From: Maria Tomalova
Sent: 19 January 2022 16:25
To: [REDACTED]
Subject: LU/396/21/DOC

The Farm 39 East Street Littlehampton BN17 6AU

Approval of details reserved by condition imposed under LU/135/21/L relating to conditions 3-full details of new external doors & windows, including sections & treatment along with details of new porches; 4-details of proposed removal of existing traditional windows; 5-details of all new internal joinery such as doors & skirting boards; 6- details of the proposed location, heights, materials & finishes of boundary treatments

Drawing Name
Elevations - Proposed Discharge of Conditions

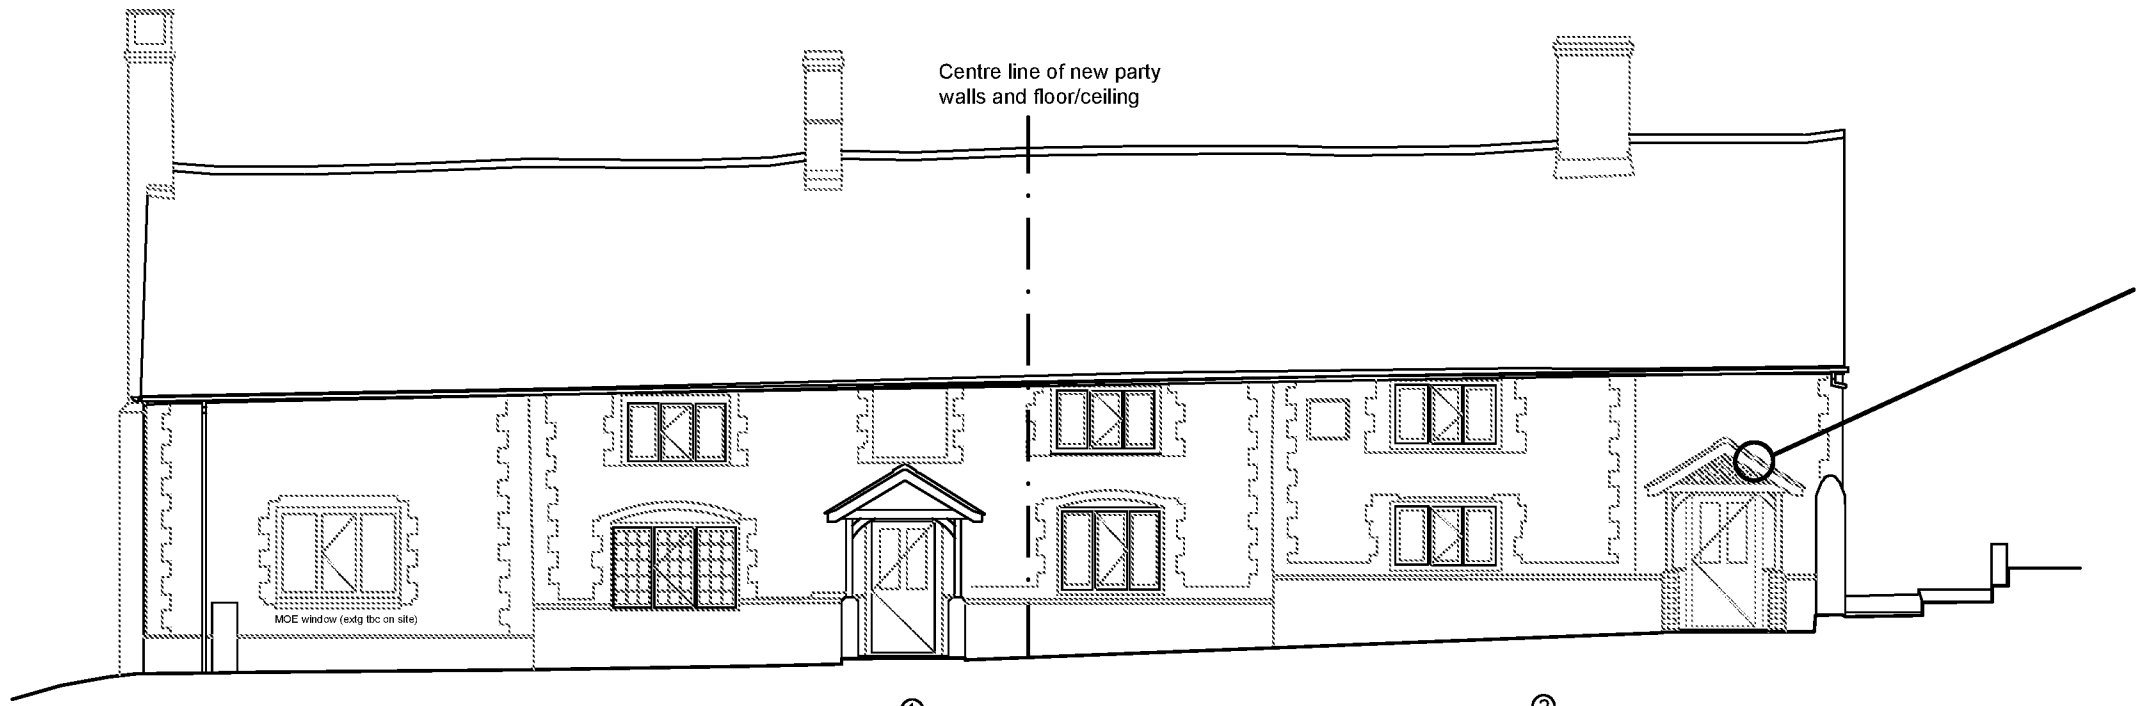
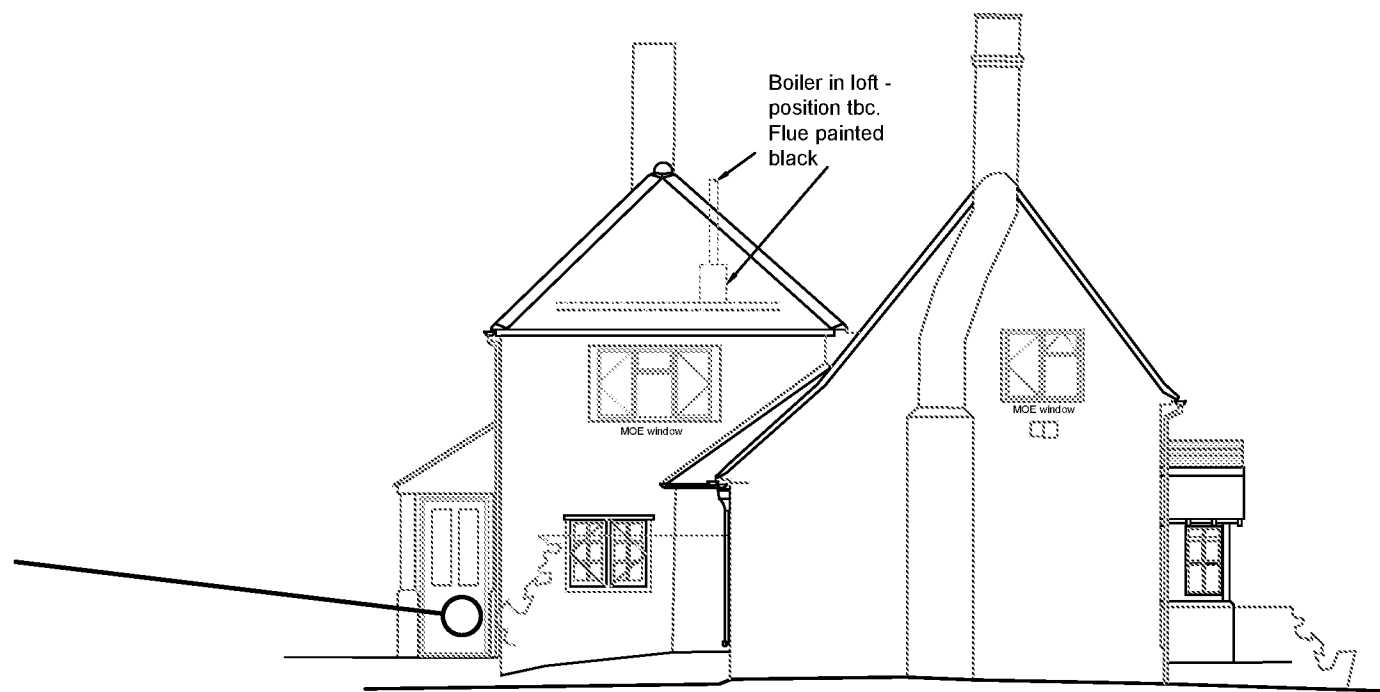
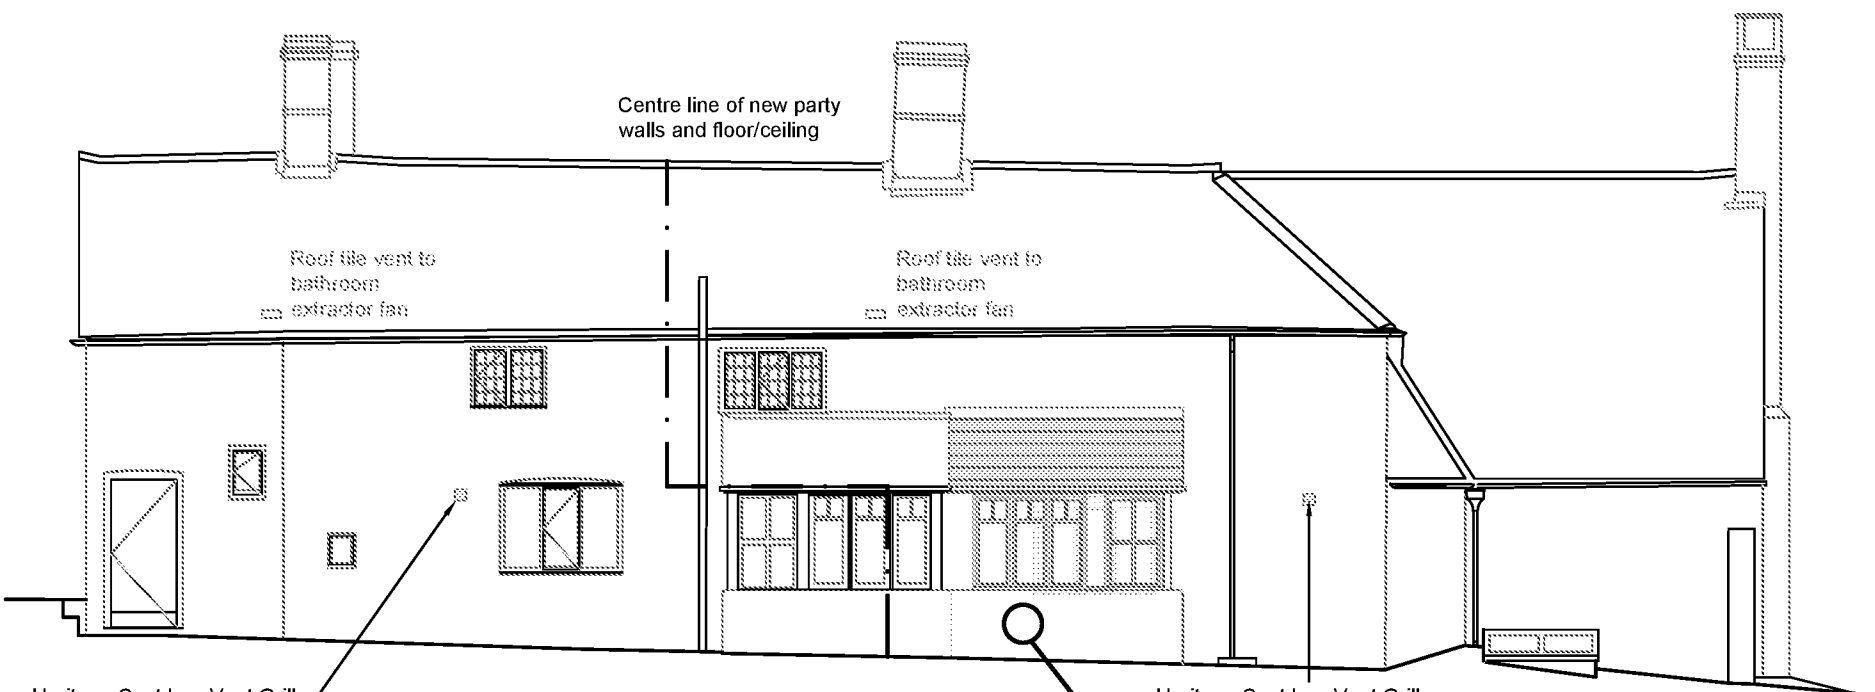
Conditions 3 & 4 – I am unable to locate the section of the windows in unit 2: GF W6 and FF W16. The statement indicates that FF W16 will match the existing first floor window on the same elevation. However, this is not fully clear from the drawing of the front elevation only. Further, I am unable to see an information regarding the window for the porch W10 or the replacement window/door identified as ED6.
